Attachment E

Outstanding Responses to the City of Sydney issues raised in response to the exhibition of the redevelopment of the IMAX Theatre and surrounding public domain (SSD 7388)

GROUND FLOOR PROPOSED  
CLEARANCES TO RMS ROADWAY  
STRUCTURES

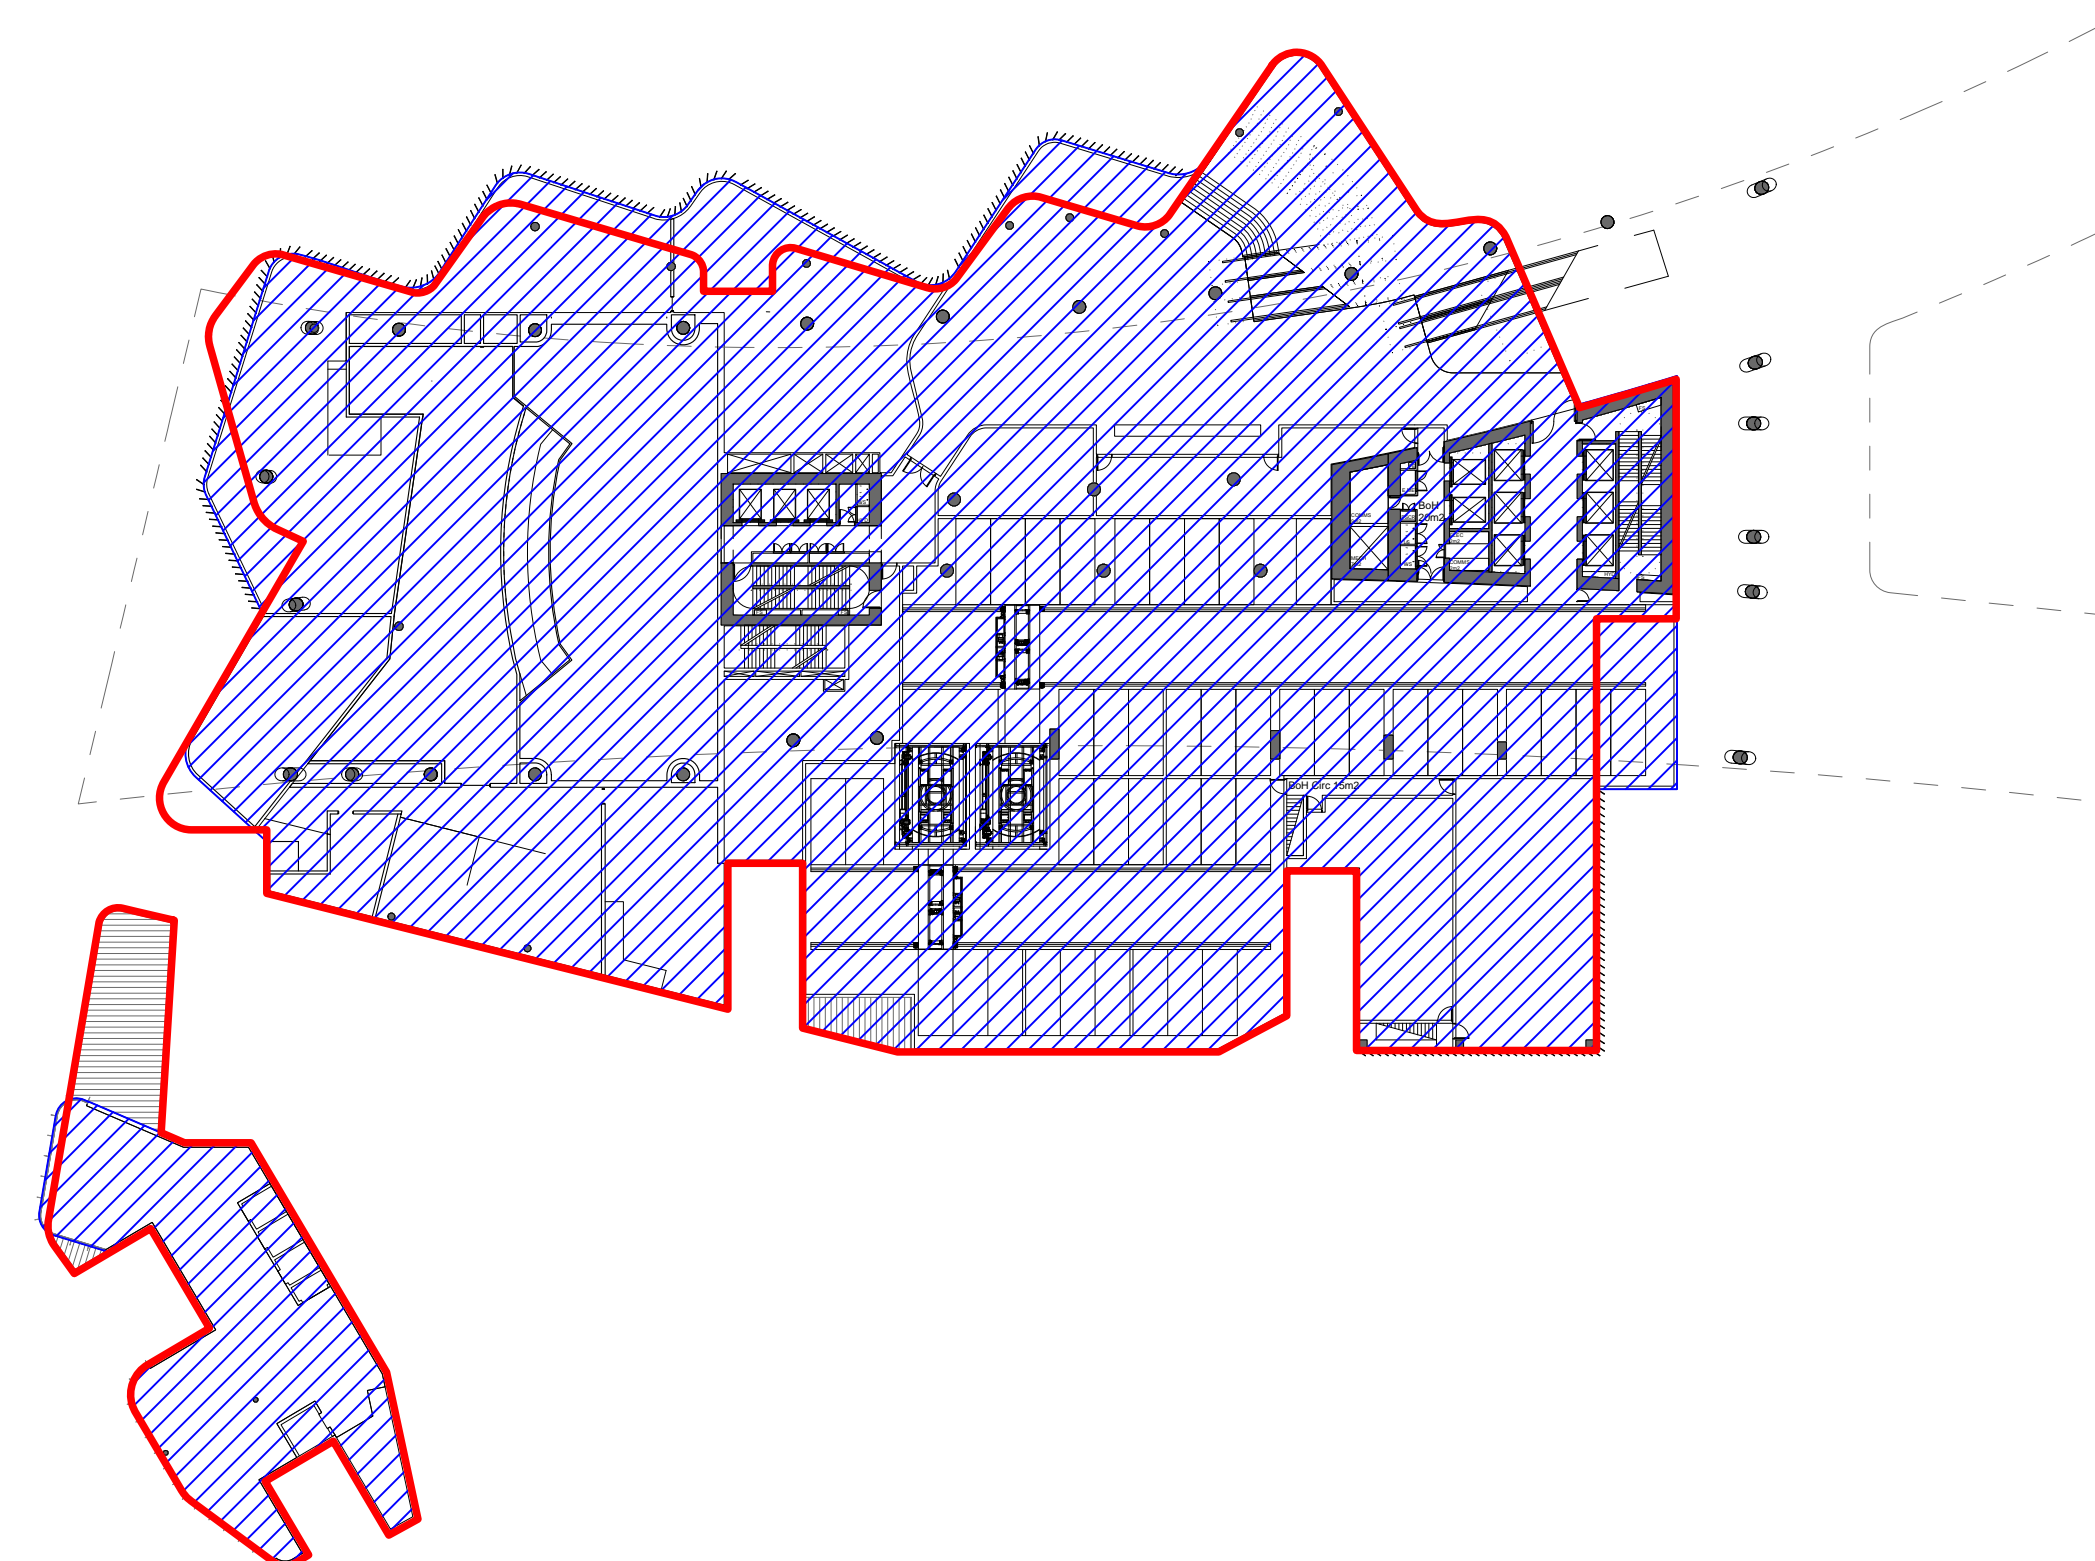
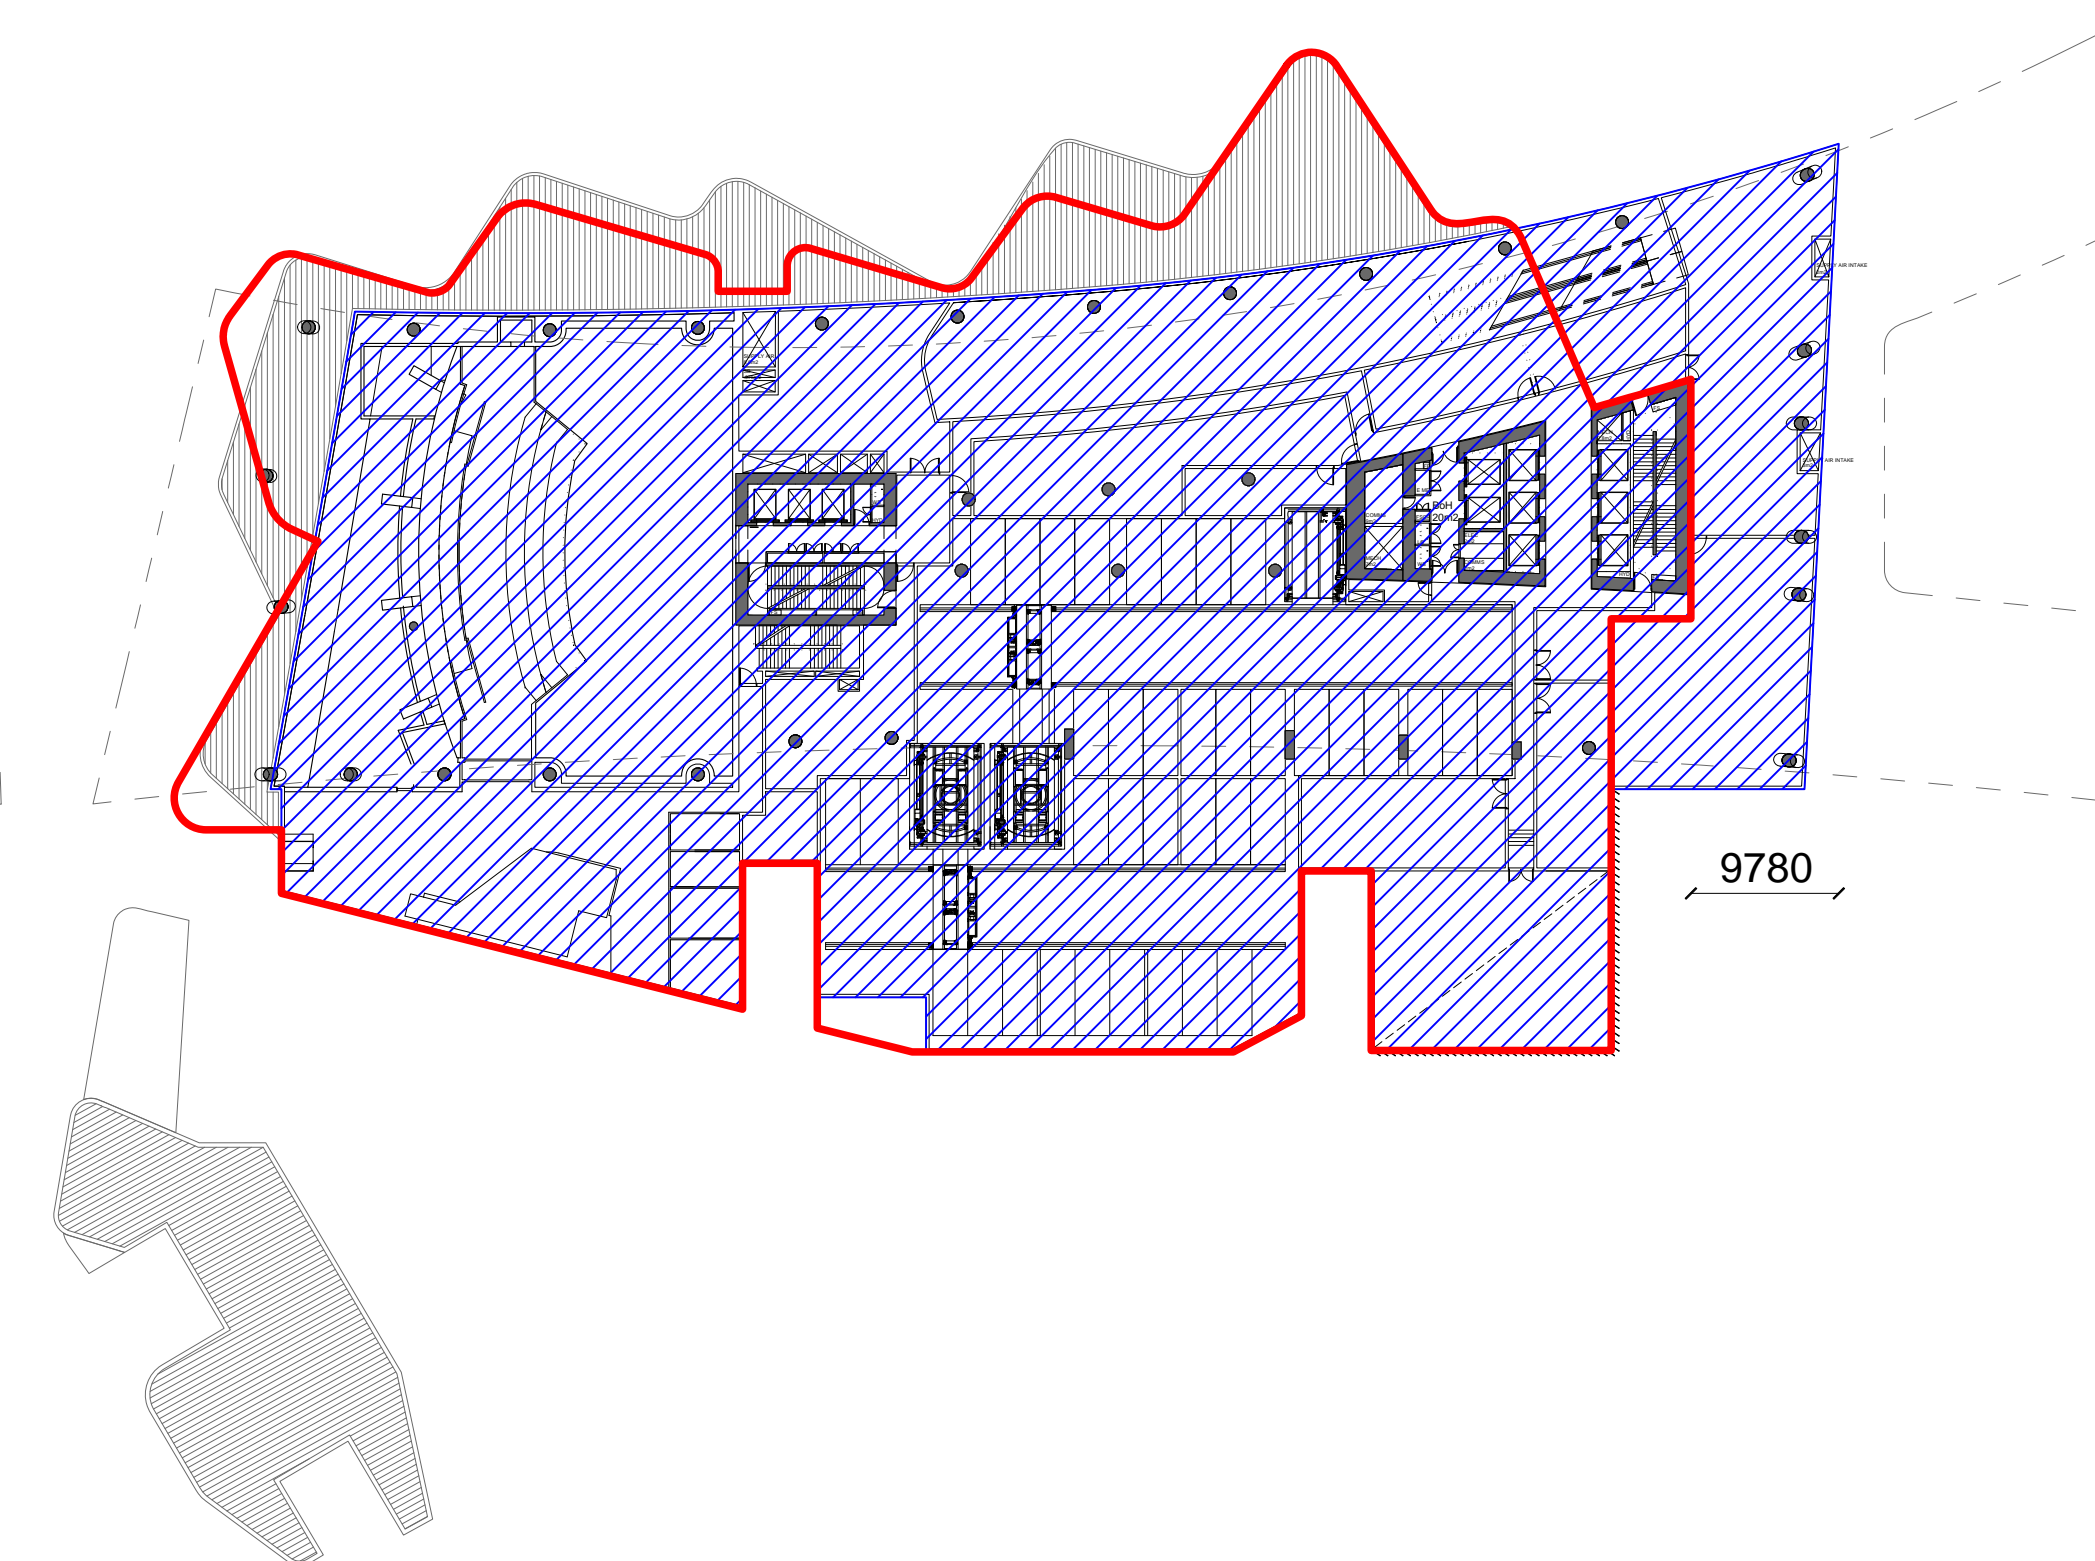
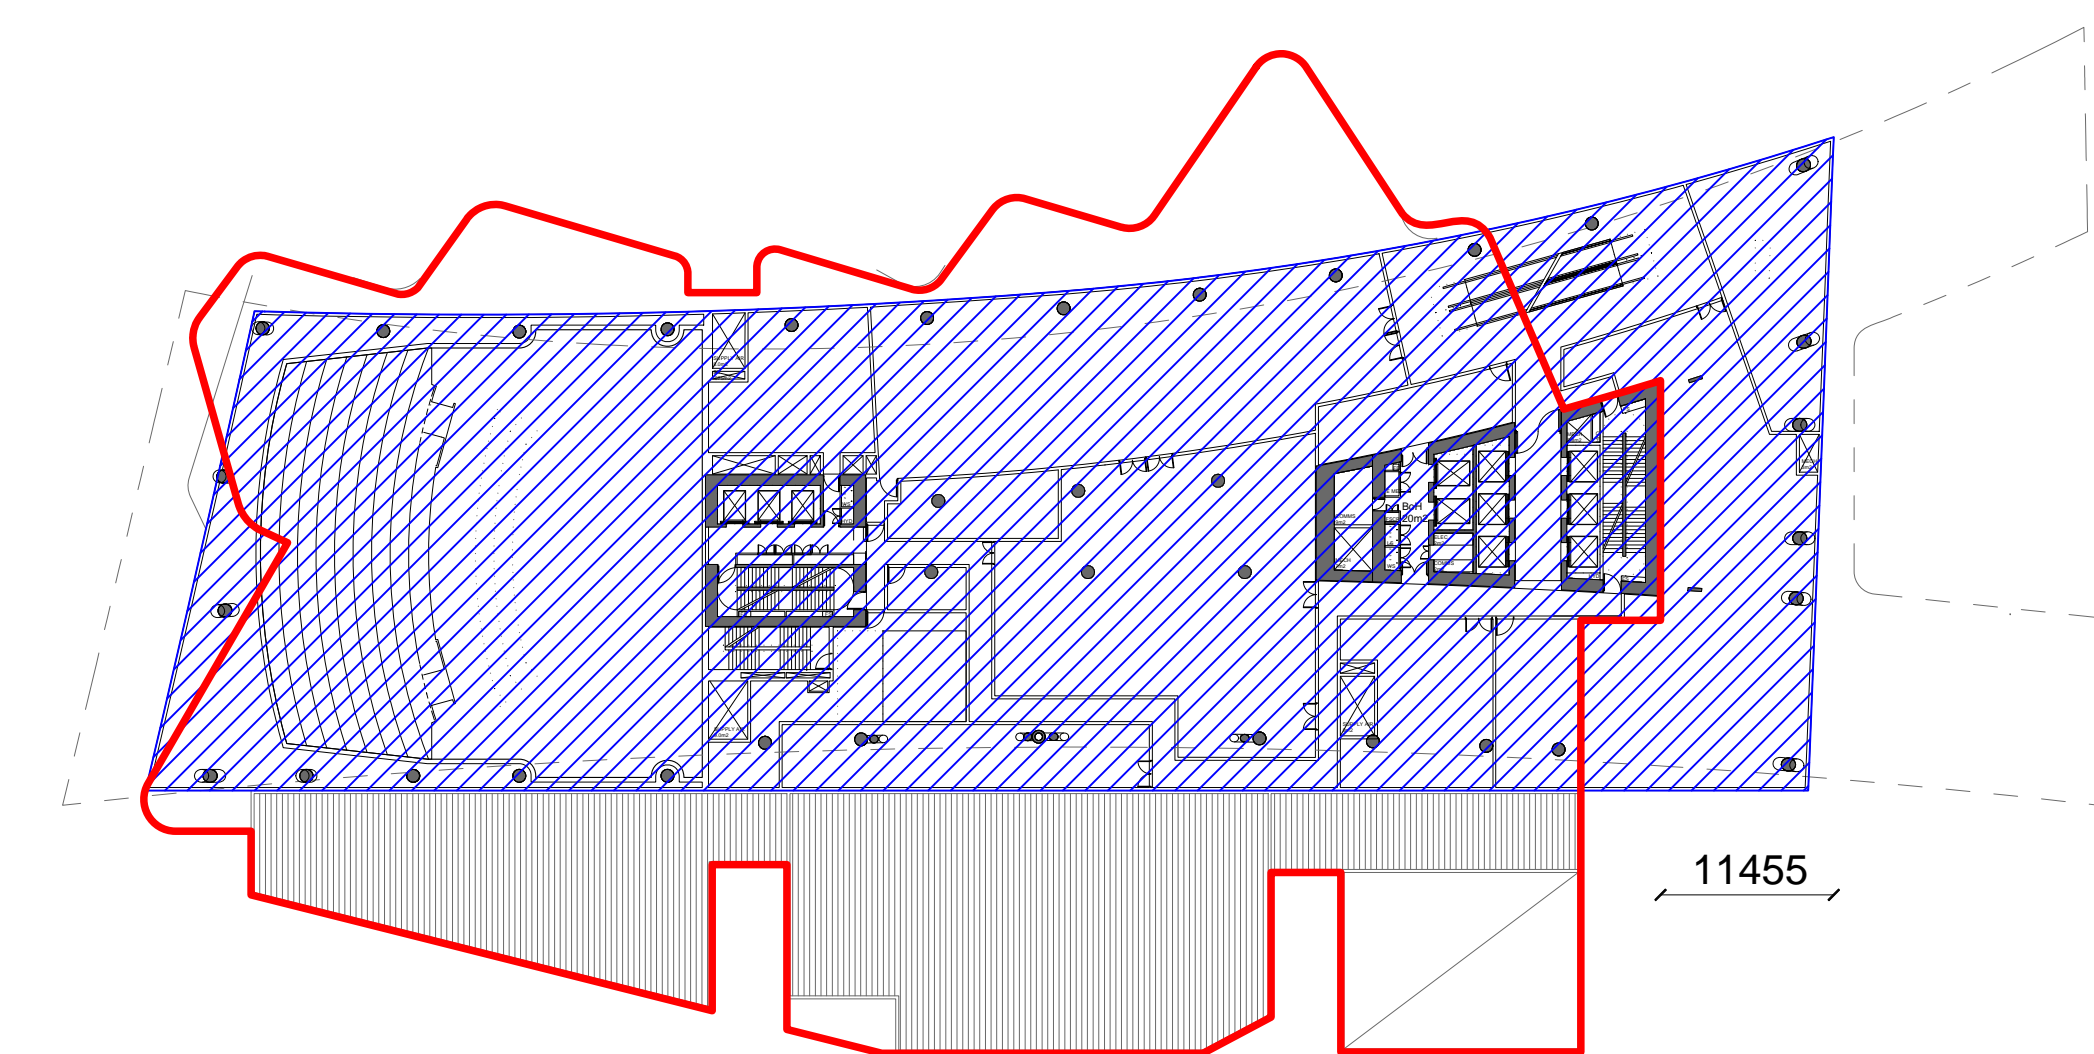
12	The proposal will result in a significant encroachment of the building into the public domain to the north and west of the building, beyond what is currently experienced. This concern was raised in the City's submission to SSD 5397 and is maintained for the current proposal.	The foot print of the building and it's impact on the public domain is very similar to that of the approved commercial scheme proposal.		As per original response.
17	Concerns are raised regarding pedestrian safety and conflict between pedestrians and vehicles crossing the vehicle entry point and around the porte cochere area. No information is provided as to how pedestrian safety will be managed. The design should include a continuous footpath across the driveway crossover to emphasise pedestrian priority and improve awareness of pedestrians and thus safety. Driveway crossing widths should narrowed as much as possible (preferably to 6m or less).	A clear pedestrian path has been provided along the eastern boundary which will not cross the porte cochere at any point;. The only point where pedestrians cross a vehicular path is located at the entrance of the loading bay/carpark. This will be clearly indicated and will not exceed 6 metres in width. - Refer to Attachment #17. The directness of the pedestrian route is largely unaffected by the development and, given the low share of pedestrian traffic accessing Cockle Bay and Darling Harbour, the development could not be expected to have a detrimental effect on the surrounding pedestrian network.	Attachment #17	The core issue of pedestrian amenity has not been addressed. The analysis provided merely examines if the pedestrian space can accommodate the pedestrian volumes in a flow rate which is acceptable. If pedestrian footpaths are reduced while accommodating increased pedestrian traffic, this will result in reduced pedestrian amenity. Further, the analysis does not look at the other issues which make up amenity (ie. directness, line of sight, lighting, use of the space for queuing /pick-up and drop- off, conflict with heavy vehicles, valet staff). Pedestrian priority should be provided across the vehicle entry to the loading dock including continuous footpath treatment. The proposed development is likely to have a detrimental effect on the surrounding pedestrian network.
